Application number: 2023/91280	
What is the application for?:	Quarrying operations for the extraction of clay, shale and incidental coal and s
Address of the site or building:	Bromley Farm Quarry, Barnsley Road, Upper Cumberworth, Huddersfield, HD8 8PD
Postcode:	S36 4HG

Type of comment: An objection	
Do you wish your comments to be published on the website anonymously?	Yes

ACCESS TRACKING

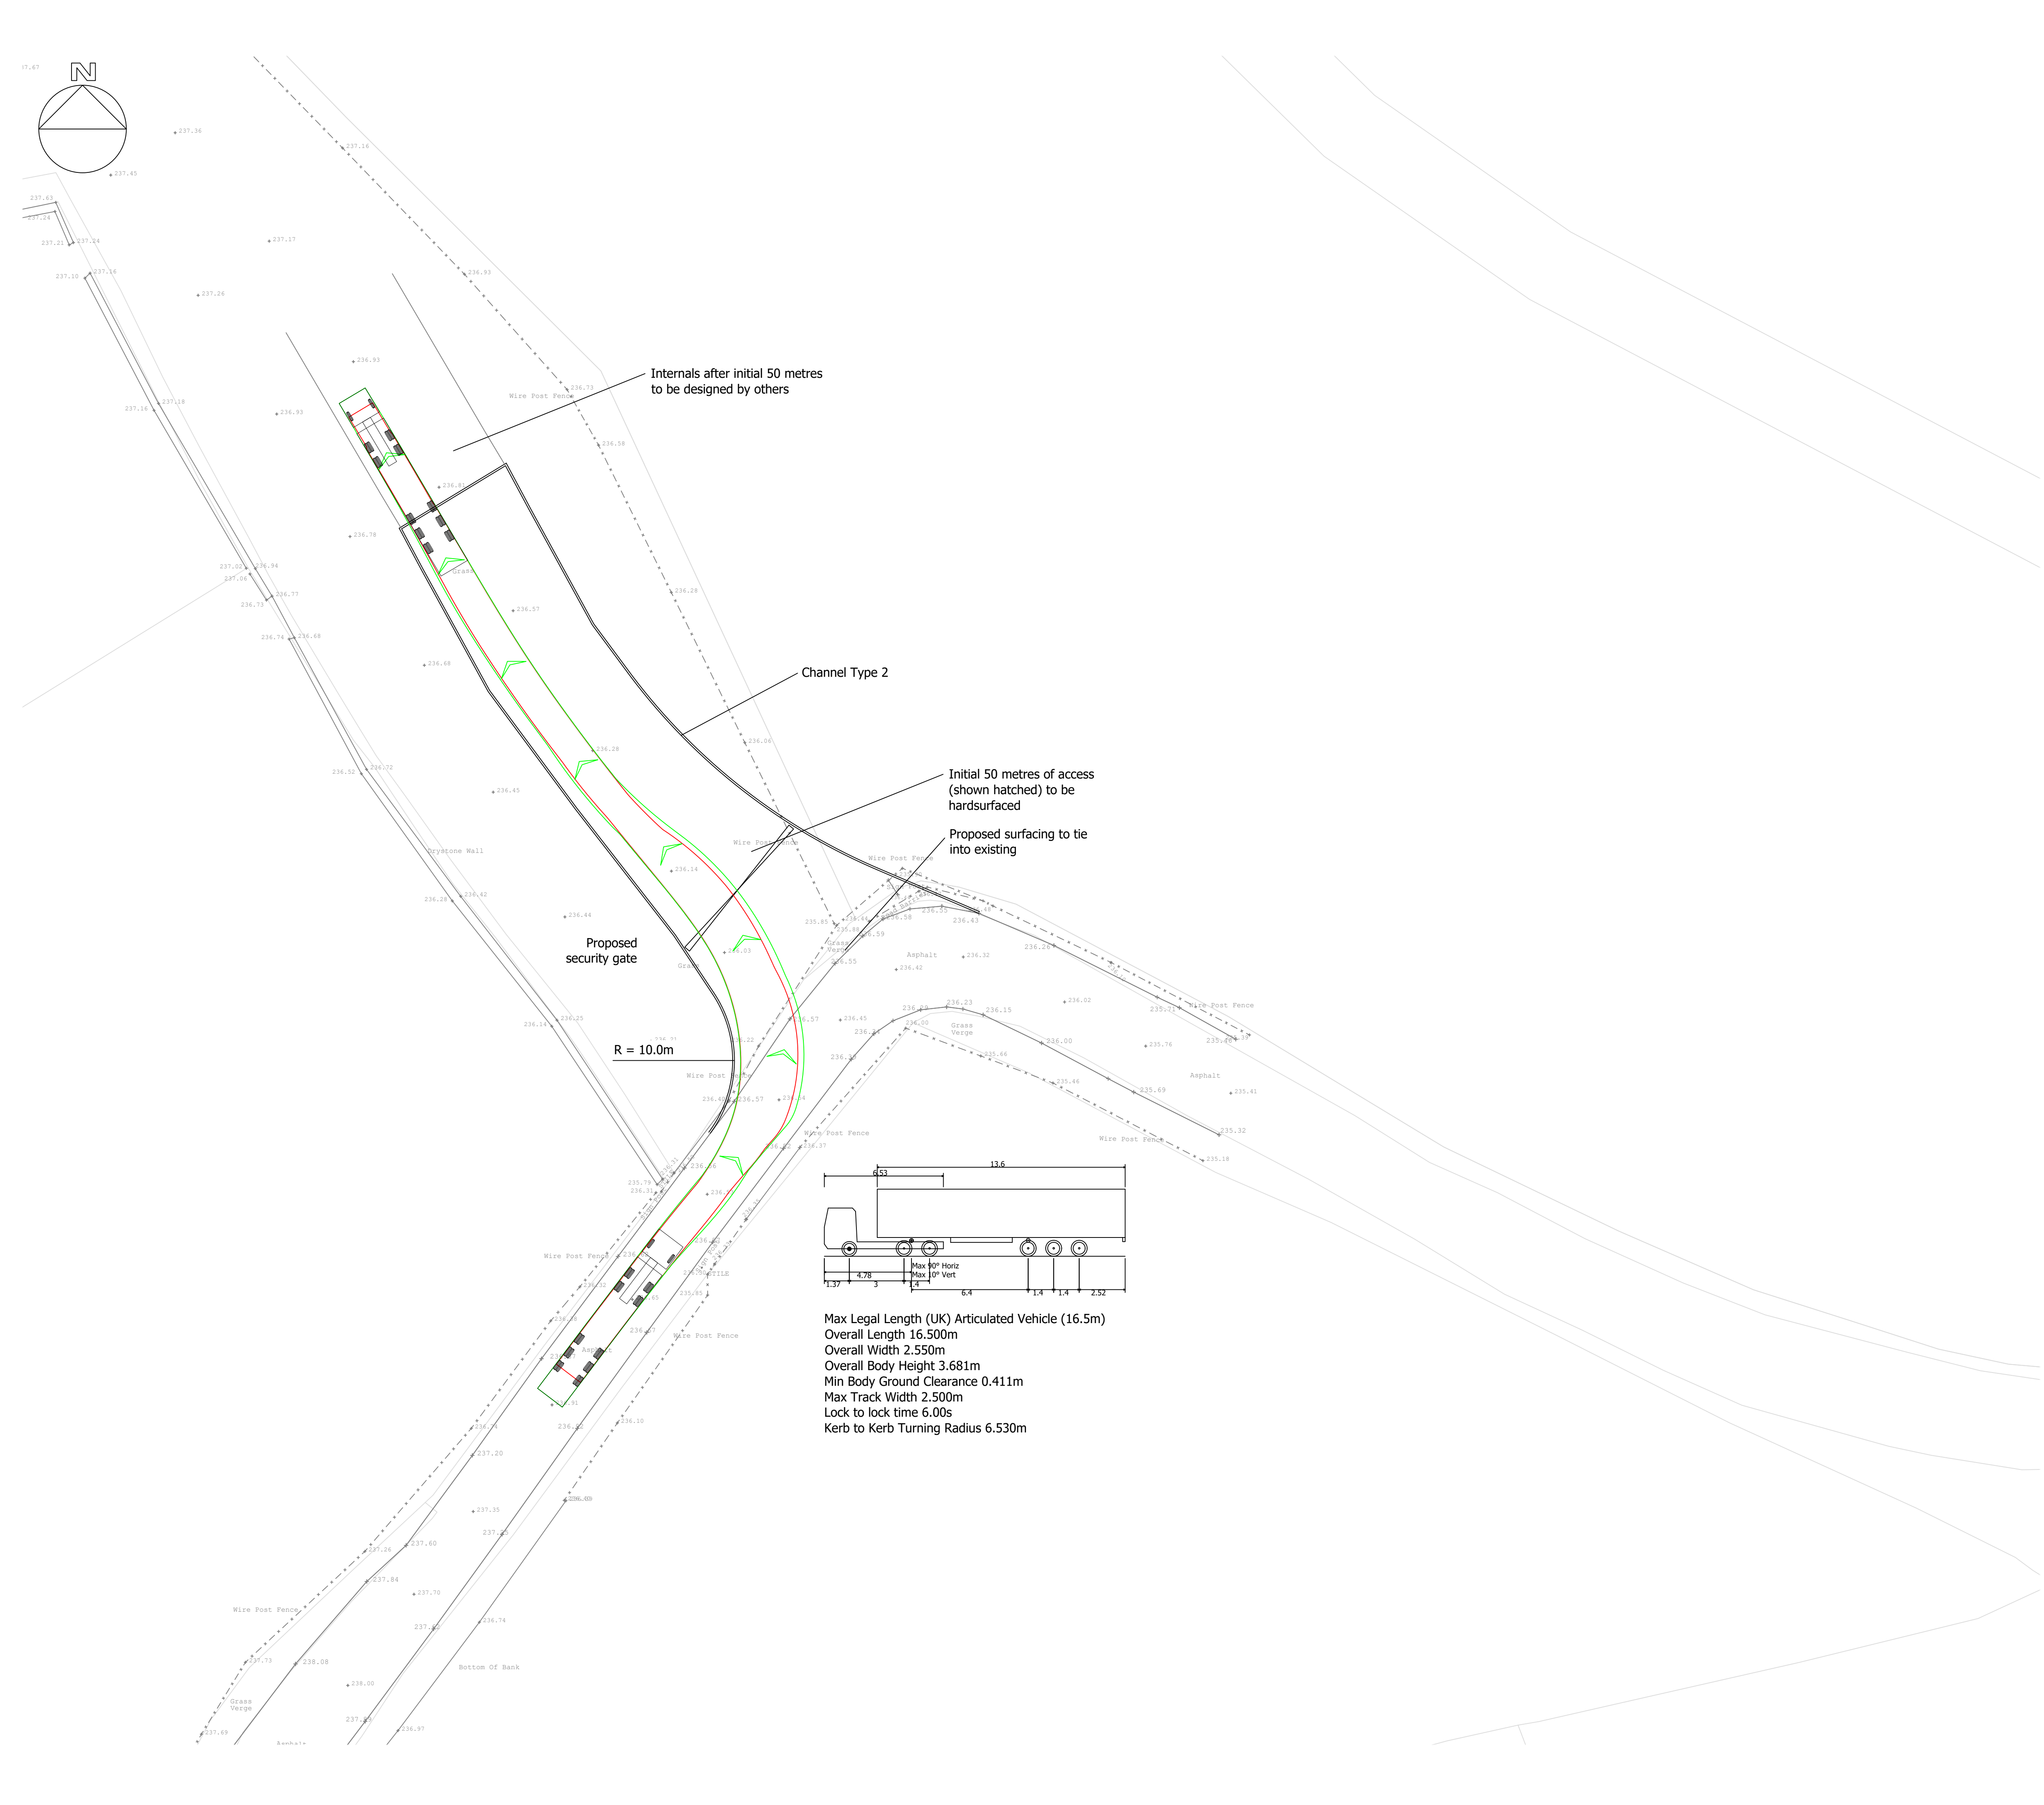
The transport assessment is woefully inadequate and fails to address the issues of the impossibility of wagons turning left at the Sovereign junction, this is already a dangerous junction and the nature of the angles, turning area and camber mean it will be extremely dangerous for wagons to use this junction. It is likely that, as current quarry lorries (PMW) do, will be to use Carr Hill road. Carr Hill road is not suitable.
